M & R HOSIER COMMENTS ON 8.18 - APPLICANT'S COMMENTS ON WRITTEN REPRESENTATION
SUBMITTED BY M & R HOSIER

40.1 Agriculture

Drawing Title
**STRUCTURES DRAWINGS
RIVER TILL VIADUCT
REGULATION 5(2)(o)
SHEET 3 OF 13**

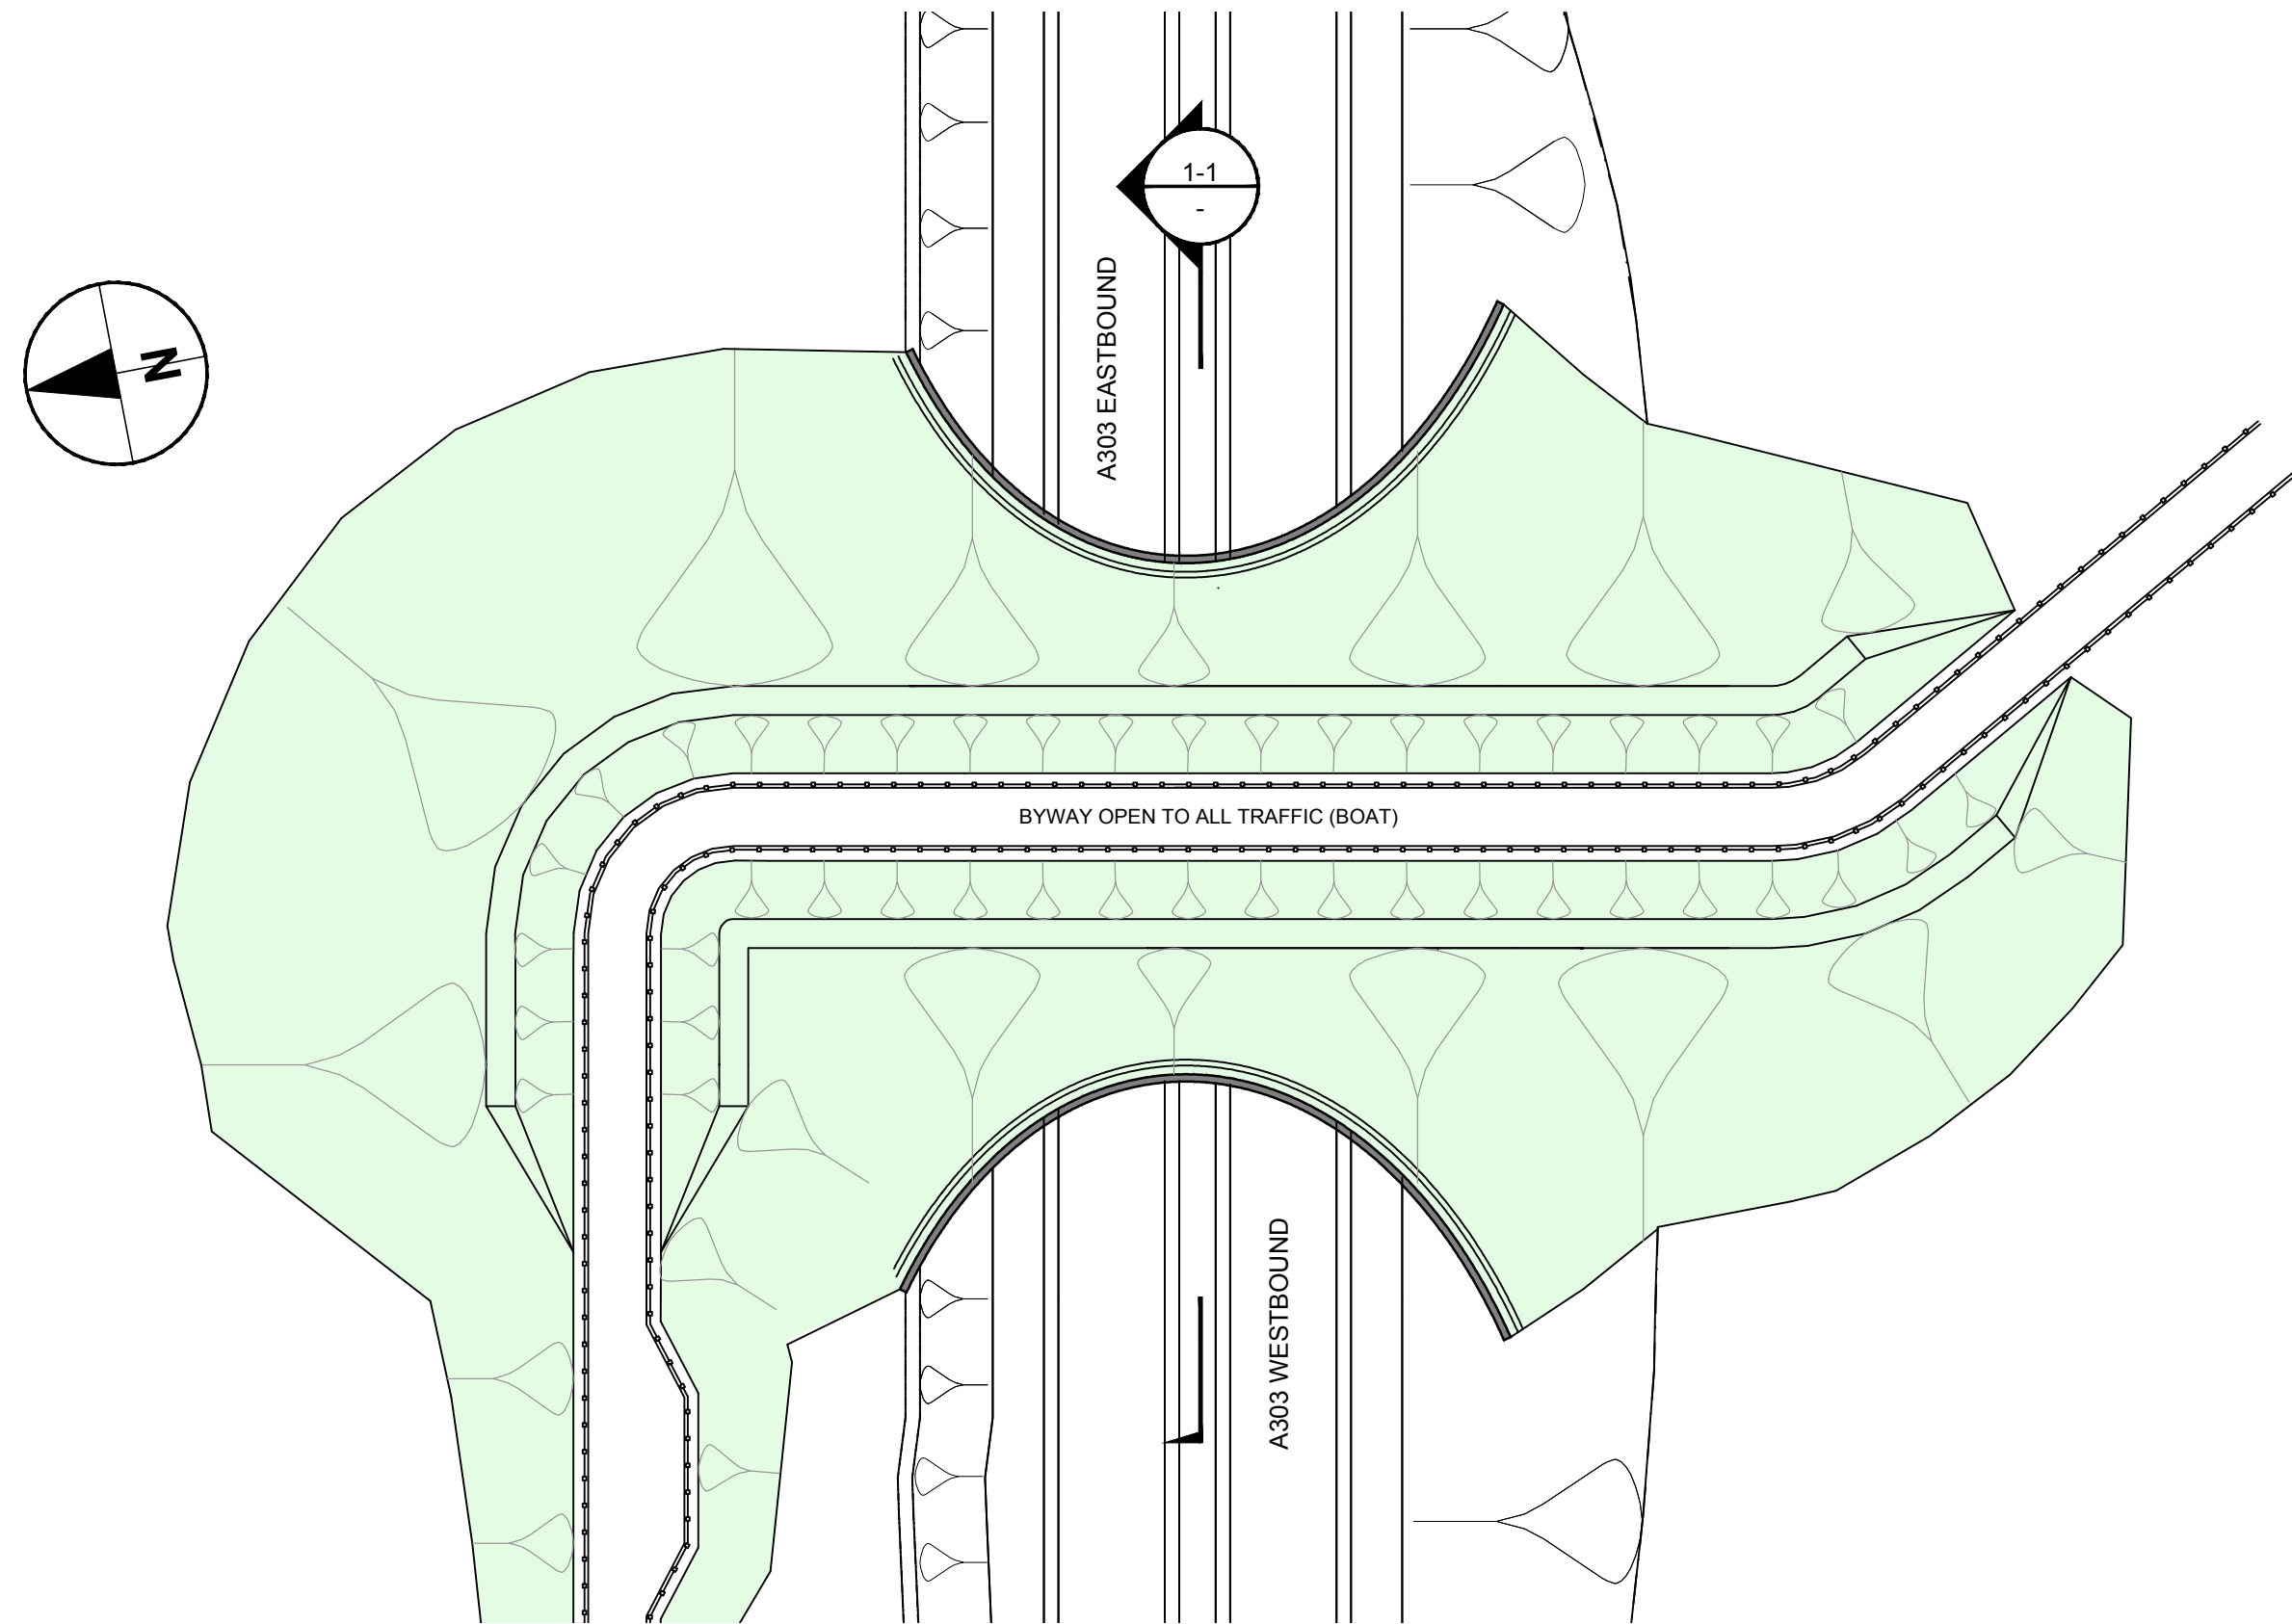
As a consequence of this, the engineering works as a result of this Scheme, will reduce the ability of the valley of the River Till to transmit and increase the amount of discharge of water into it. Quote “10.3.1 *River Till viaduct*: the introduction of piers into the River Till floodplain has potential to interrupt flood flows and create a local backwater effect.”

The Applicant admit the piers in the River Till will interrupt flows but there are other aspects that HE have not considered:-

- a. The construction of the foundations in the ground and piles of the bridges bridge will reduce the storage capacity of the hyporheic zone of the River Till and its ability to transmit water southwards. This will cause the groundwater to rise and increase risk of flooding.
- b. The road embankment on the eastern side of the River Till reduces the width and flood storage in the flood plain.
- c. The weight of the road embankment will cause compaction, closure of the fissures in the Chalk and so reduce storage and permeability of the ground.
- d. Runoff from the A303 will be discharged via ponds into the valley of the River Till and will increase the risk of groundwater flooding and pollution.

- a. Whether the Figure 5.2 River Till Flood Depth 15AEP Plus Climate Change 40% produces flood levels which are lower or higher than recorded in Autumn 2000 as shown by the mark on the willow tree and 1841.
- b. What will be the impacts of the engineering works mentioned in relation to the piers in the River Till on increasing the height of flood waters. Flooding always carries the risk for pollution should house drains be filled to capacity, causing dirty water to enter the groundwater.

Drawing Title
STRUCTURES DRAWINGS
WESTERN TUNNEL PORTAL
REGULATION 5(2)(o)
SHEET 8 OF 13

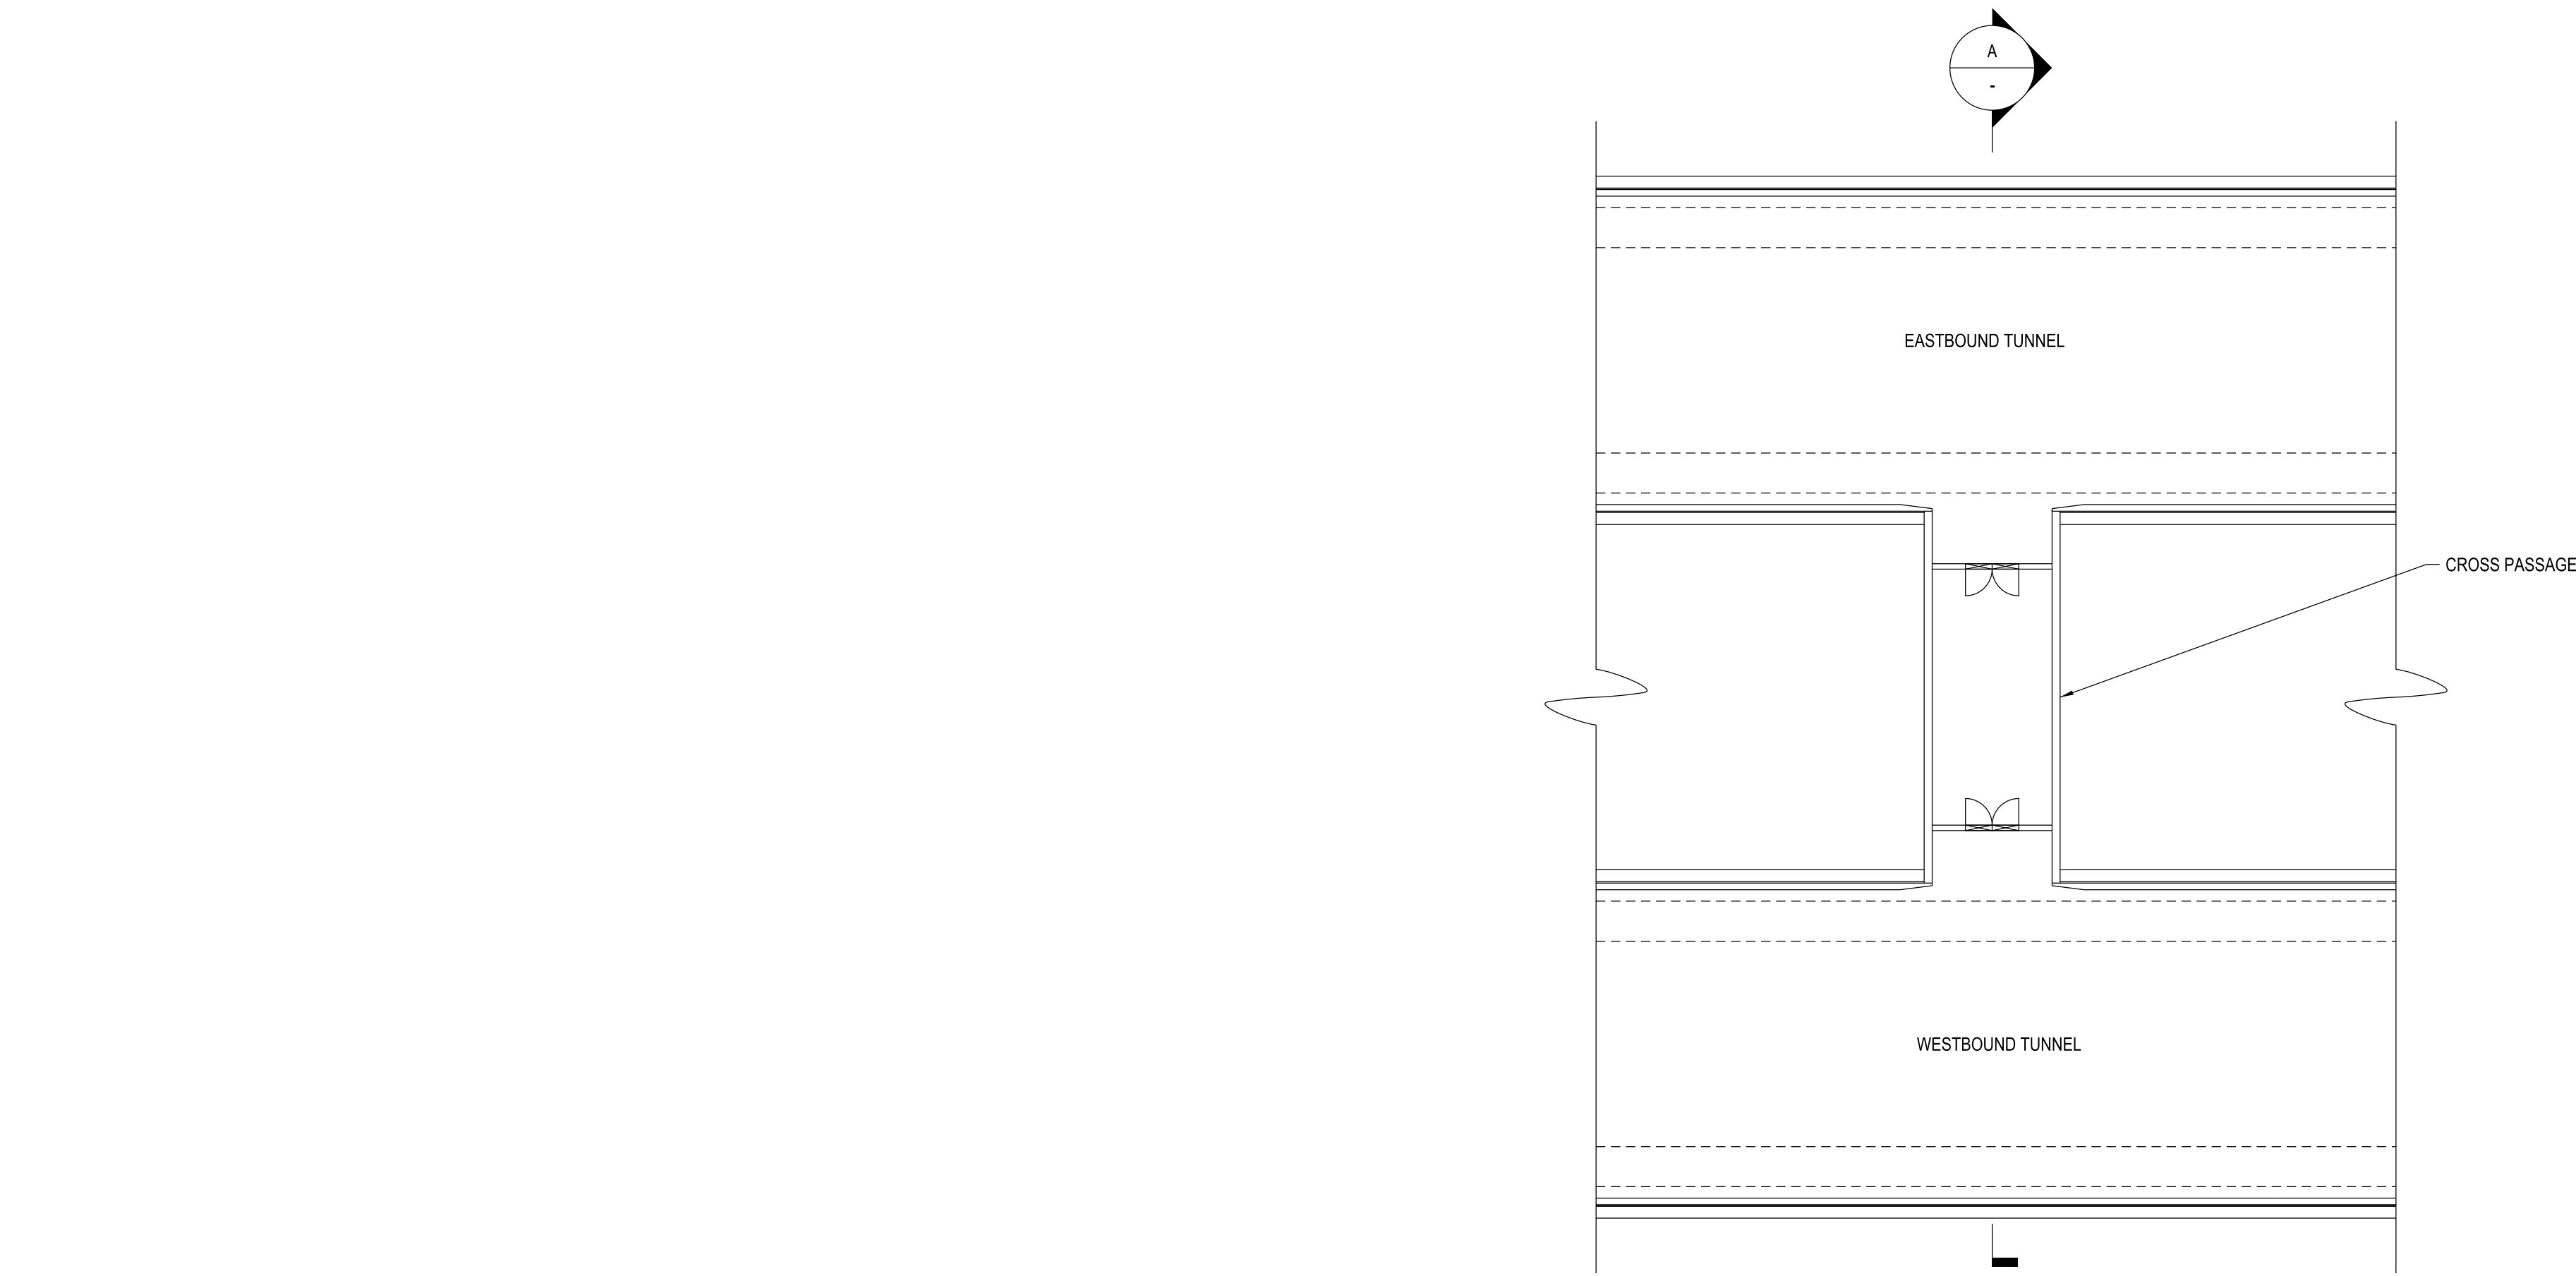
No information has been provided on the limits of deviation and whether that includes deviation of the length of the tunnel and the width of the carriageway. What is the width of area of the chalk grassland creation to the south of the tunnel? It appears that it will be another awkward area of land to manage that will be an added cost to the ongoing maintenance of the scheme, for questionable benefits.

40.1.7 The land identified for permanent acquisition around the tunnel has been reduced to the minimum required in order to construct, operate and maintain the tunnel. It does, however, include a Limit of Deviation, within which the tunnel will be located following detailed design. Highways England will only acquire that land that is identified as required for permanent acquisition once the final detailed design is confirmed. With reference to the Environmental Masterplan [APP-059], some land has been identified for essential mitigation around the tunnel to enable the portals to be set below ground levels or replicate ground levels as far as practicable and integrate the approach to the portals for landscape and visual integration, in combination with areas of new species rich chalk grassland for nature conservation and biodiversity.
